## Application for a Non-Material Amendment Following a Grant of Planning Permission

Land at Crow Trees Farm, Crow Trees Brow, Chatburn

Proposed erection of 37 affordable residential units with access, parking and landscaping. Conversion and extension of former dairy outbuilding to open-market residential unit and refurbishment/modernisation of Crow Trees Farmhouse (open-market dwelling) including reconfiguration, rooflights, side window and extension of two outbuildings to form garages.

3/2022/0966

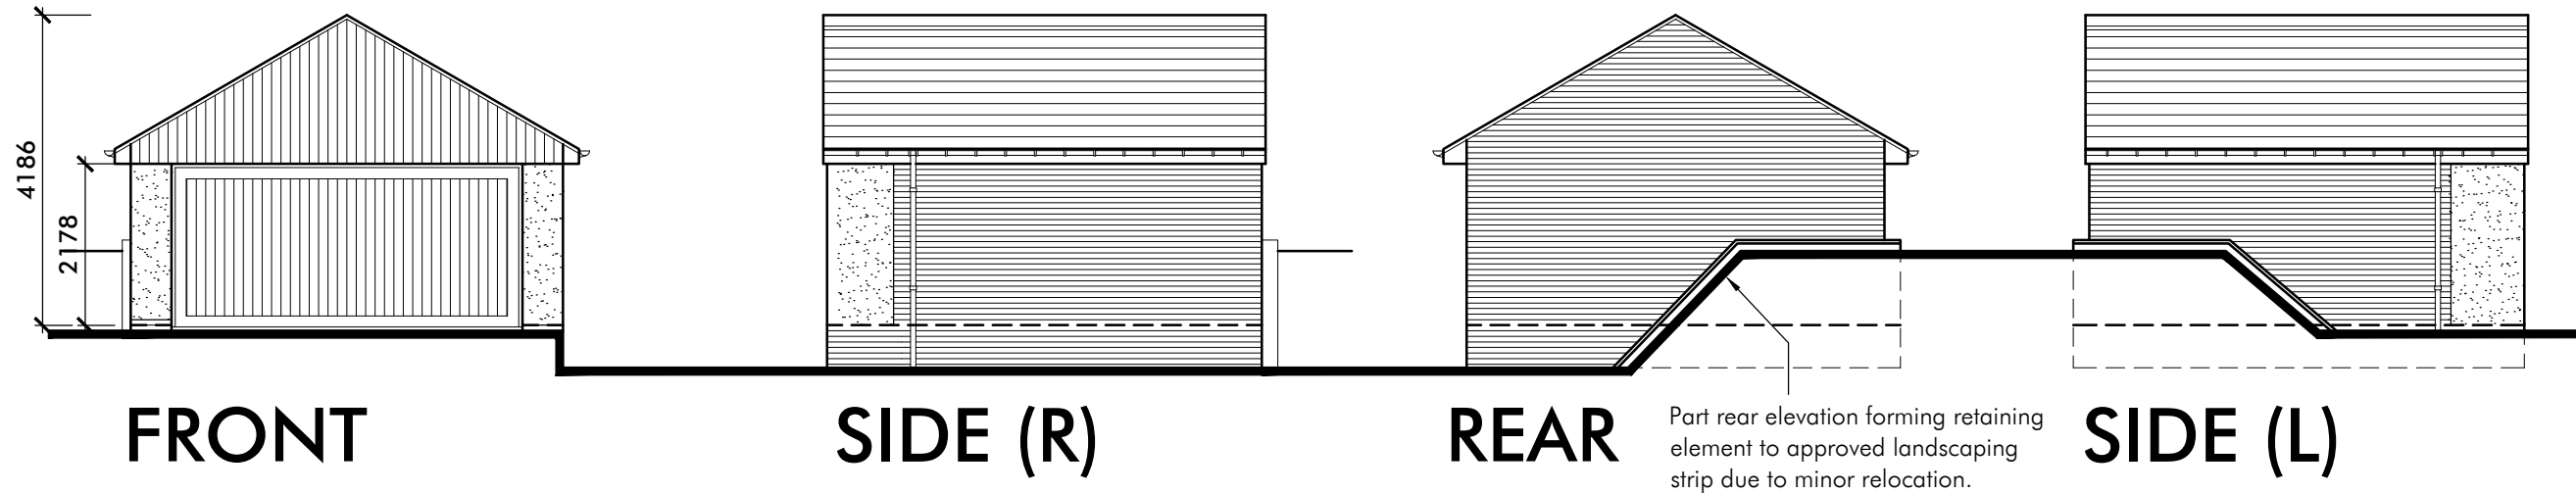
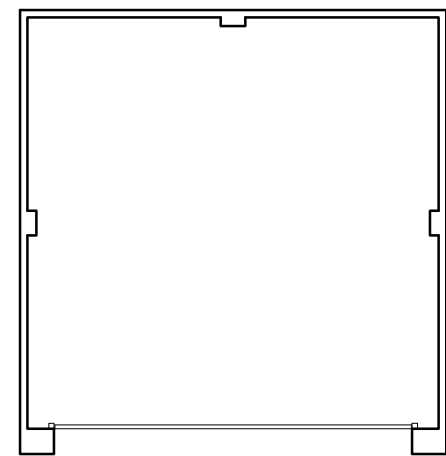
Amendments to external materials and windows to rear elevations of dairy building conversion and garden room, amendment to external materials and door position to ancillary building conversion, minor re-positioning and external materials amendments to garage to rear of dairy building conversion

- Site Layout Plan ref 21/139/P01rev K
- Proposed Barn Conversion and Extension Floor Plans and Elevations ref 21/139/CO2rev B
- Detached Garage to Barn Conversion Plans Elevations and Section ref 21/139/ G04revA
- Proposed Dutch Barn Conversion Annex Accommodation to Dwelling Floor Plans and Elevations ref 21/139/CO3rev B.
